## REQUEST

Current Zoning: M&L-1 (manufacturing and logistics 1), CG (general commercial), N-1A (neighborhood 1-A)  
Proposed Zoning: R-12MF(CD)

Approximately 24.13 acres located on the south side of Mount Holly Road east of the intersection with Creston Circle.

The petition proposes to allow redevelopment of a site currently occupied with three single family dwellings, a triplex residential building, and two small commercial buildings with a multifamily residential community of up to ~~288~~ **268** dwelling units.

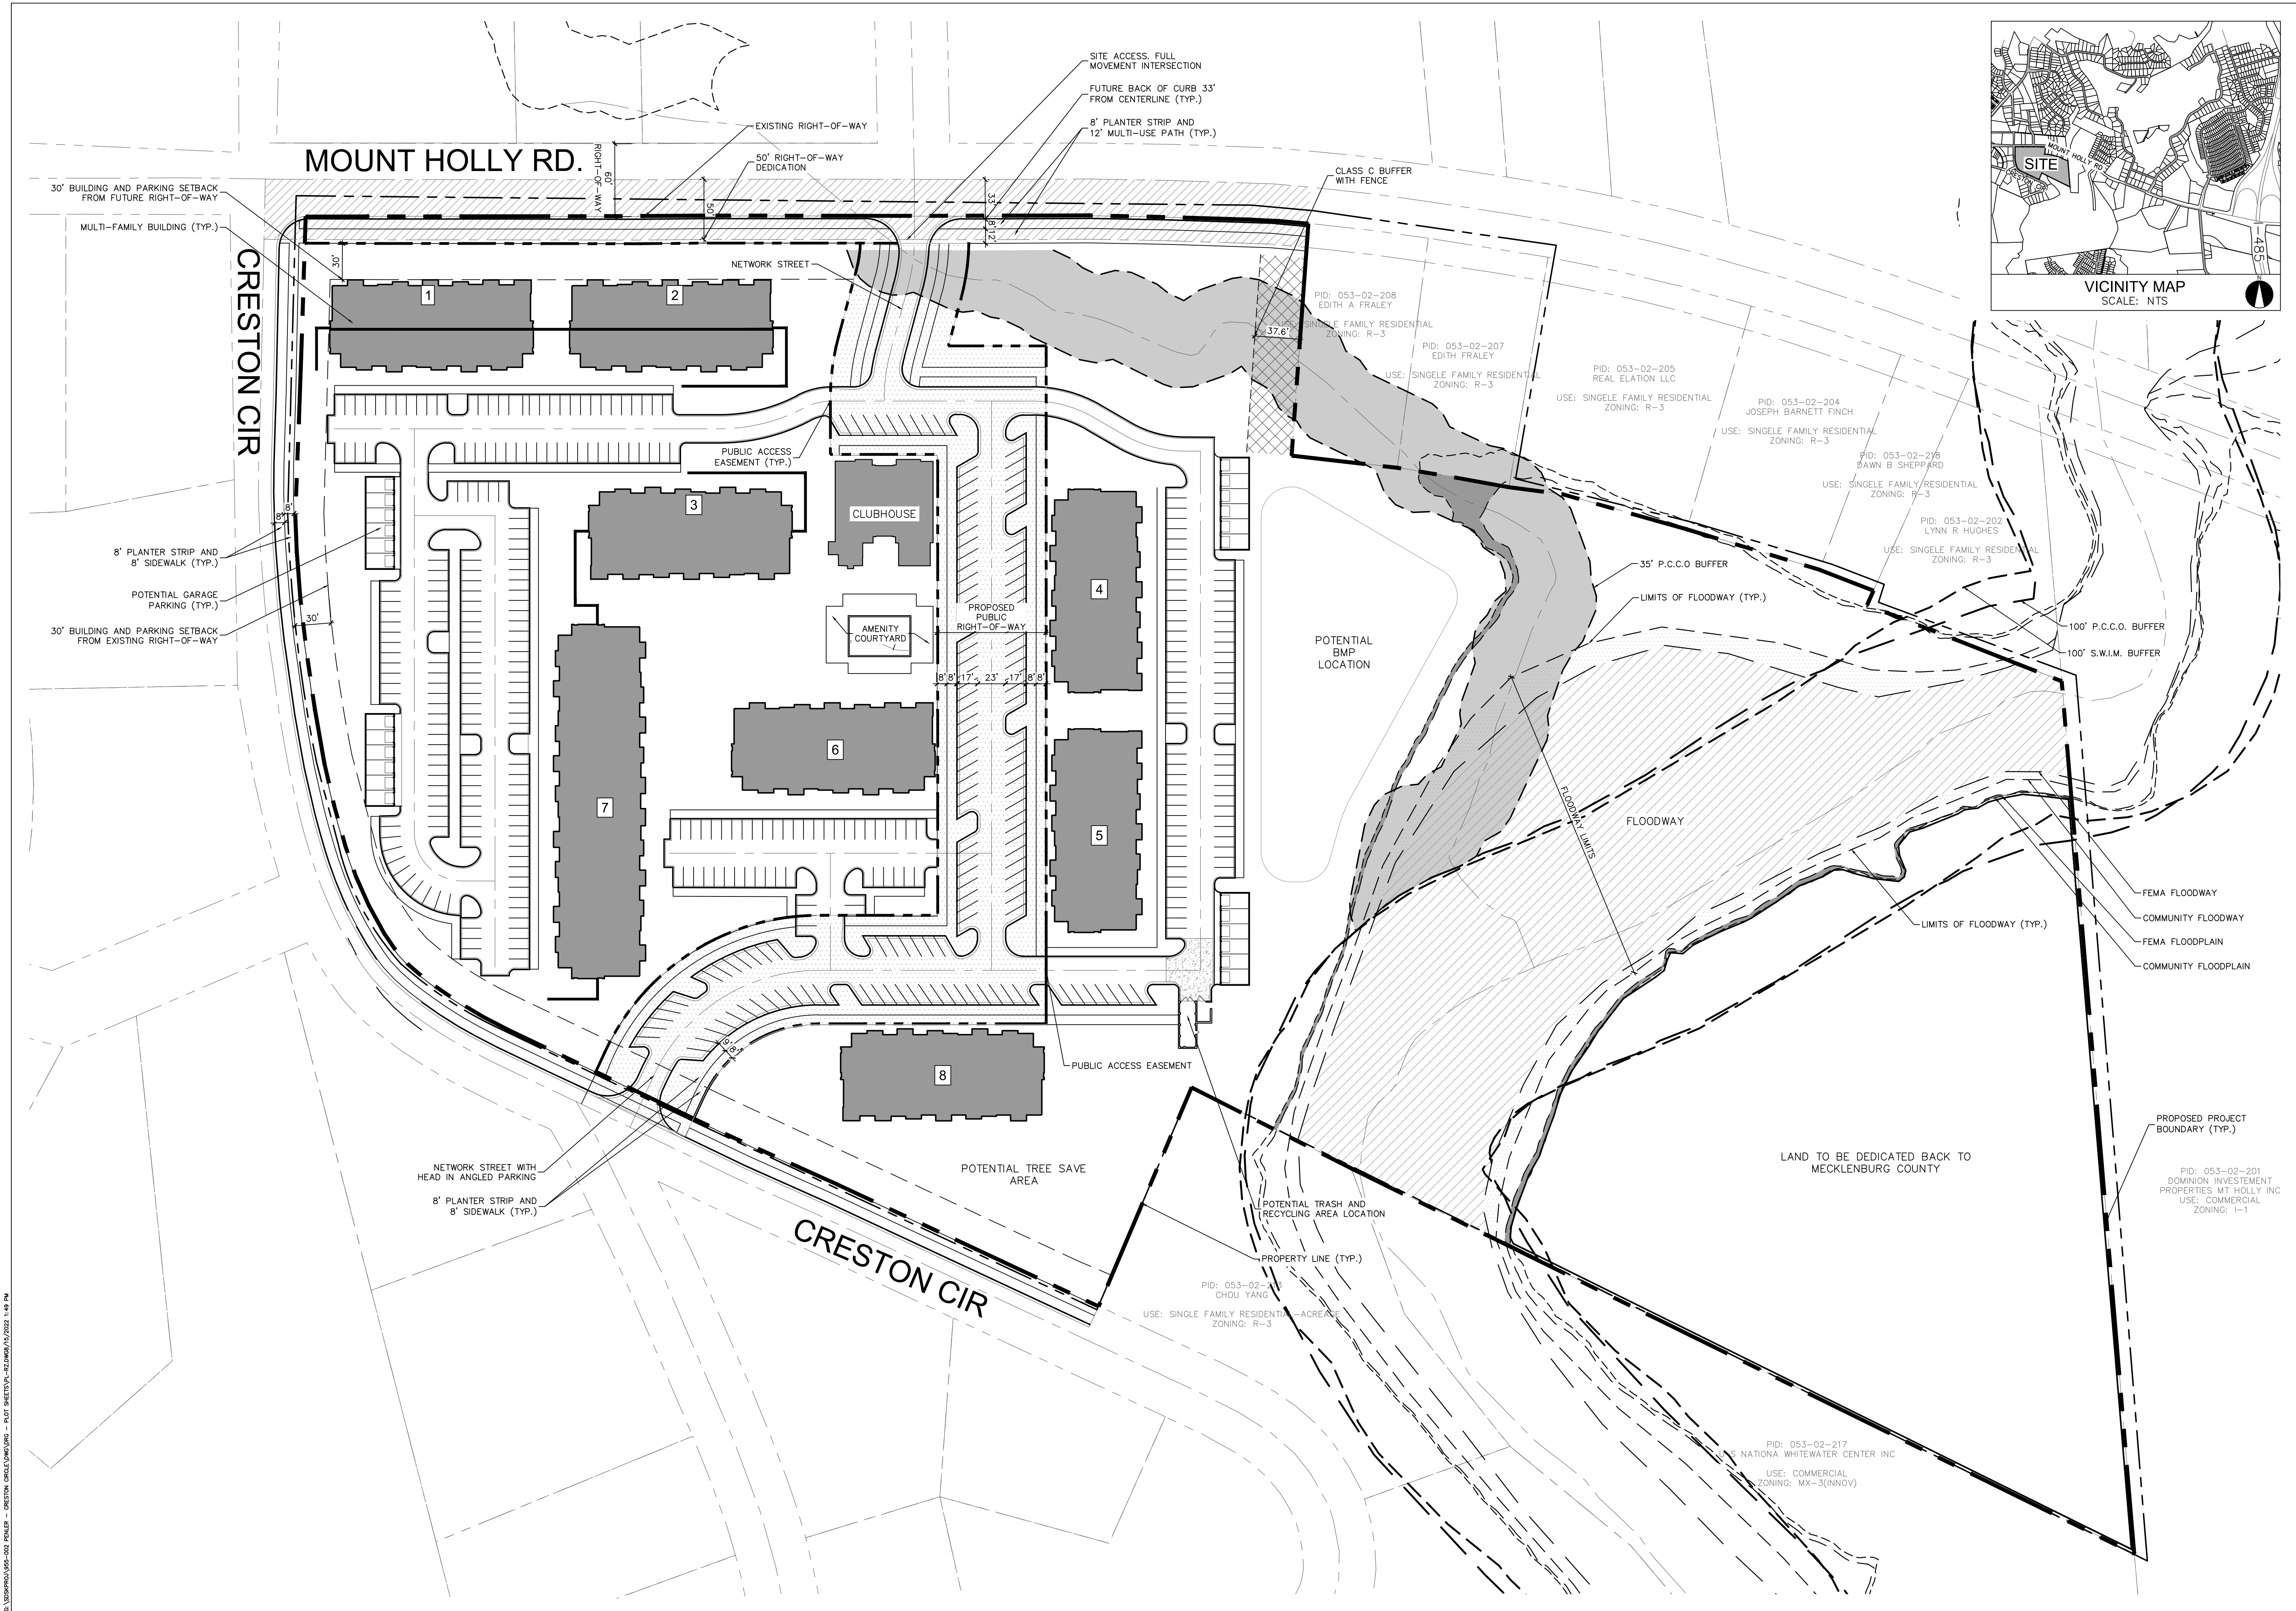
1. ~~Label and dimension the Mount Holly Road future back of curb at 33' for entire Mount Holly Road frontage. Label and dimension the Creston Circle curb and gutter to be installed at 17.5' from centerline in accordance with the Local Residential Wide typical section (CLDSM U-03).~~ **ADDRESSED**

2. ~~Revise site plan and conditional notes to commit to upgrading Creston Circle to the proposed site access in accordance with the Local Residential Wide cross section (CLDSM U-03).~~ **ADDRESSED**

3. ~~Remove or modify the proposed phasing for the development (Note J). Creston Road improvements need to be completed prior to first CO for the site, or a more balanced phasing plan needs to be proposed. The current proposed phasing based on CO for building 8 leaves too much public infrastructure work outstanding for the last building based on the overall project scope, and it is not proportional. Updated comment: Update proposed note to include buildings 4-8. Creston Road improvements need to be completed prior to first CO for the site, or a more balanced phasing plan needs to be proposed. The current proposed phasing based on CO for building 4 leaves too much public infrastructure work outstanding for the last building if buildings are not constructed in sequence, and it is not proportional. In addition, Creston Circle improvements should be completed prior to access to Creston Circle is permitted.~~ **ADDRESSED**

4. ~~Extend the proposed greenway access easement to the public street right-of-way so that Mecklenburg County can access the dedicated parcel area.~~ **ADDRESSED**
5. ~~Provide a tree survey identifying all trees of 8" DBH or greater and all planted trees of 2" caliper or greater and 6' in height that grow partially or wholly within the city right-of-way.~~ **ADDRESSED**
6. ~~Label tree save on the site. The tree save area must be outside of the area to be dedicated to Mecklenburg County.~~ **ADDRESSED**
7. ~~Ensure that all parking spaces and garages are outside of the setback.~~ **ADDRESSED**
8. ~~Ensure that the buildings meet the 27' or 30' setback due to lack of entries on the street elevation.~~ **ADDRESSED**
